**SSD-9351535, JOHN HUNTER HEALTH & INNOVATION PRECINT – 29 KOOKABURRA  
CIRCUIT NEW LAMBTON HEIGHTS**

TfNSW have reviewed the following documents:

Figure 6 – Proposed Construction Access

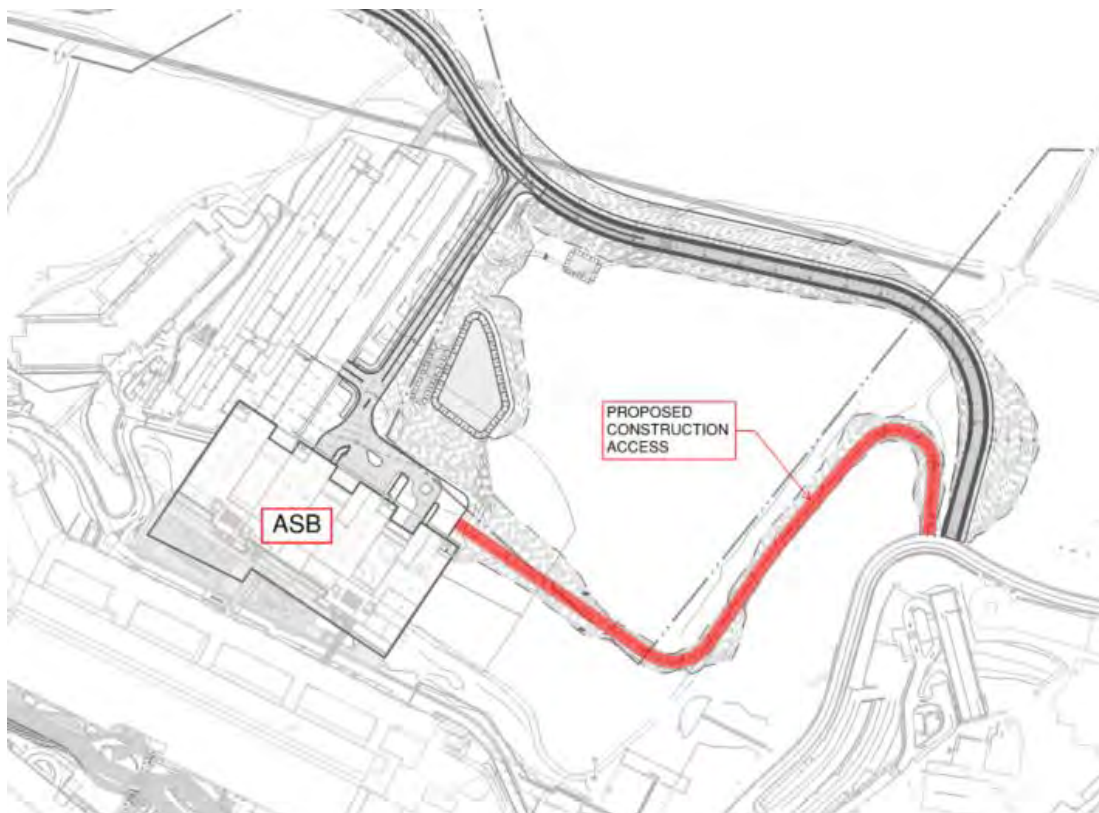
- Safety and efficiency - Using the signalised intersection of Lookout Road / Kookaburra Circuit for early works and / or construction related traffic access / egress should be avoided as the intersection is the main thoroughfare for emergency vehicles, staff, pedestrians and visitors. Other construction access options may include the intersection at Jacaranda Drive (outside of peak traffic volume periods) or the access for NICB construction activities. TfNSW would encourage coordination through the NICB / JHH steering committee for advice and direction about access.

Figure 11 – Onsite detention basin locations

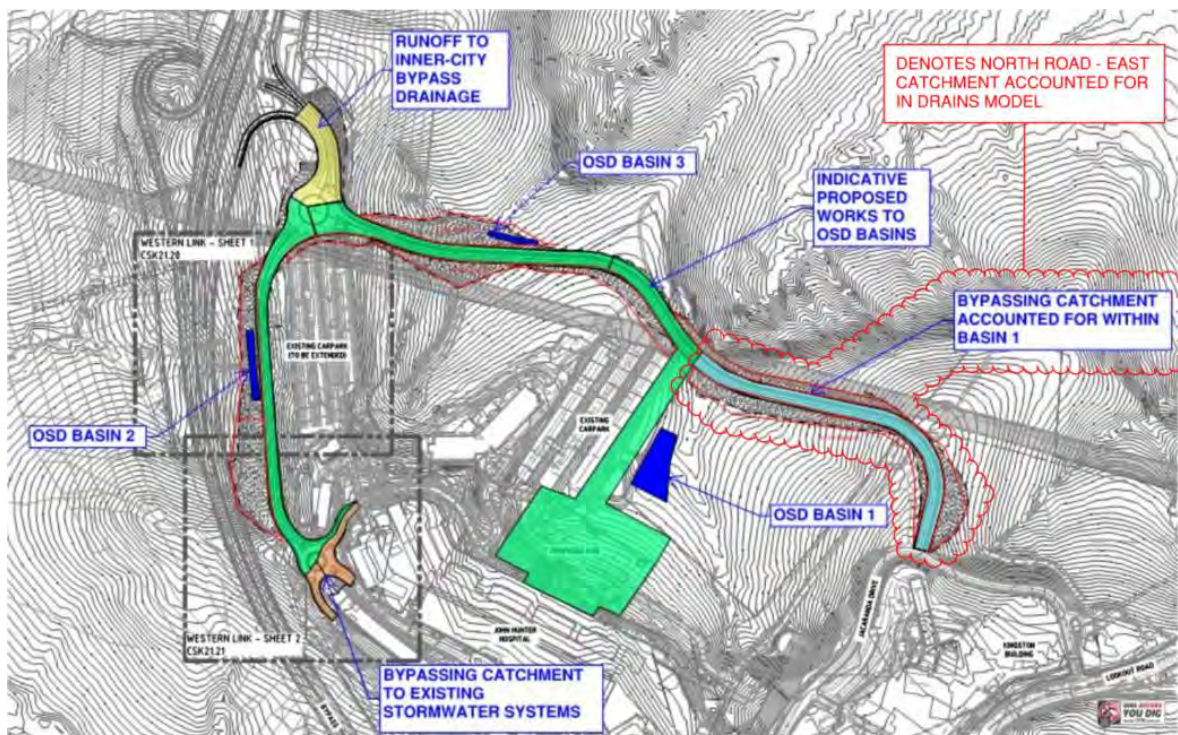
- Stormwater Management – A combined sediment / biofiltration / detention basin - number 2 - is located immediately upstream of the NICB (located on the eastern side). Discharged stormwater from this system shall not exceed the capacity of the stormwater drainage system identified in the current design, which is for swale / catch drain and stormwater culvert system. This civil infrastructure is identified at Chainage 8630 of the concept Aurecon Design.
